Young High School SSD (9671) – Modification 3: Landscaping Changes – Heritage Council of NSW Comments

- Letter from Ethos Urban to DPIE, titled *Section 4.55(1A) Modification Application (SSD-9671) Young High School Library and Joint-use Community Facility*, dated 24 September 2021, and its attachments.

**Figure 2** Proposed Tree Protection and Removal Plan for Carrington Park (modifications are clouded)

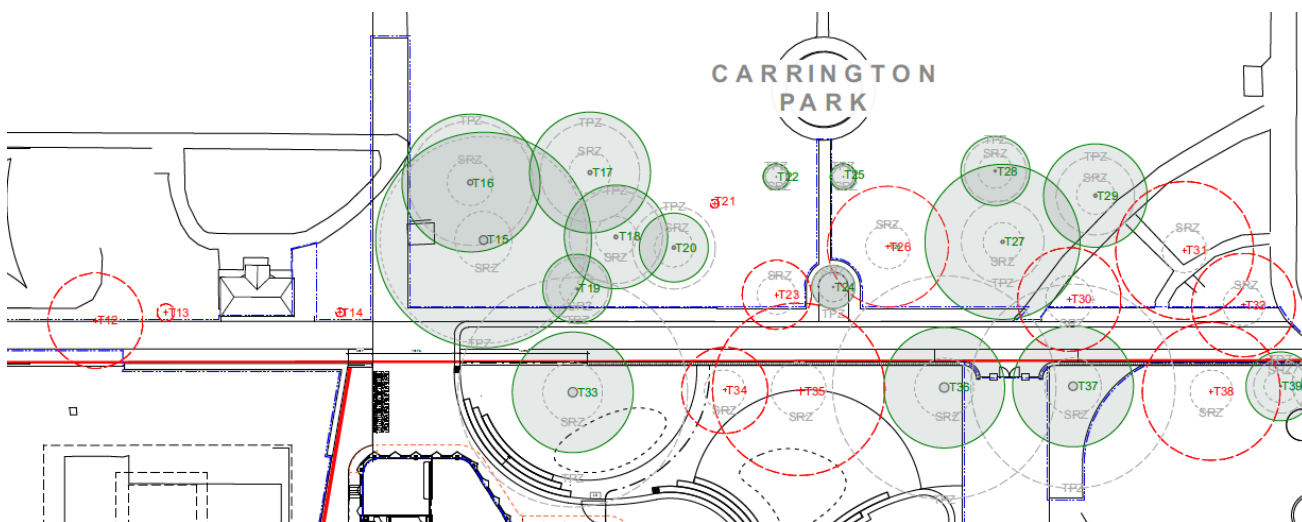
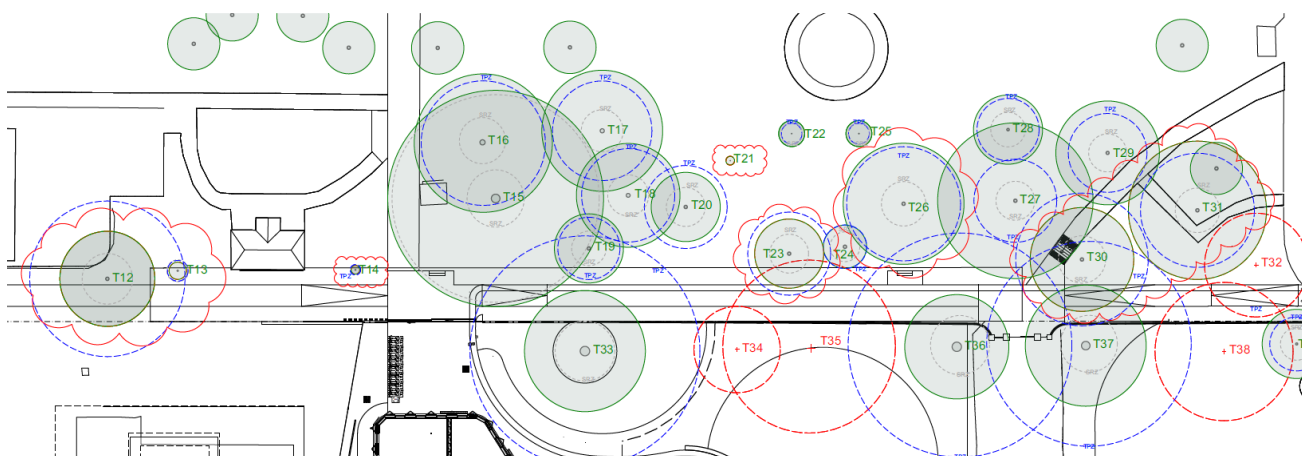
- The proposed changes also include new potential impacts (the tree removals) within areas of high to very high archaeological potential (Lantern Heritage, *Addendum to Historical Archaeological Assessment and Research Design*, August 2021) which are not acknowledged or addressed in the modification application. Further changes to surfacing within the school playground (e.g. asphalt, soft fall and synthetic turf surfaces) have not been reviewed against the known and potential archaeological resources of the site. It is unclear whether the depth of these elements and associated subbases may impact archaeological resources of significance, or not.

- Page 2 of the modification application indicates that Heritage NSW requested the removal of the trees within Carrington Park in front of the former Courthouse (Building AA). This is not the case as Heritage NSW has never made any formal request of this kind. The removal of these trees was proposed by the proponent to restore historic lost views of the former Courthouse. This was identified in the 2018 EIS to be a moderately positive impact of major positive impact of the proposal (p.35/38 and 46). If these

positive impacts are now being removed the proponent needs to reconsider the overall heritage impacts of the project.

- As such, I recommend that a short SOHI is prepared which includes a section discussing the archaeological impacts. It should assess the potential impacts of the proposed changes on the heritage significance and archaeological resources associated with the Lambing Flat Riot Site SHR nomination as supported by the Heritage Council of NSW.

- If the SOHI identifies that impacts to State significant values including State significant archaeological resources will occur, then it should outline how the impacts will be avoided. If they cannot be avoided further detail on how they will be mitigated, and if required, managed, should be supplied including justification for the proposed approach.
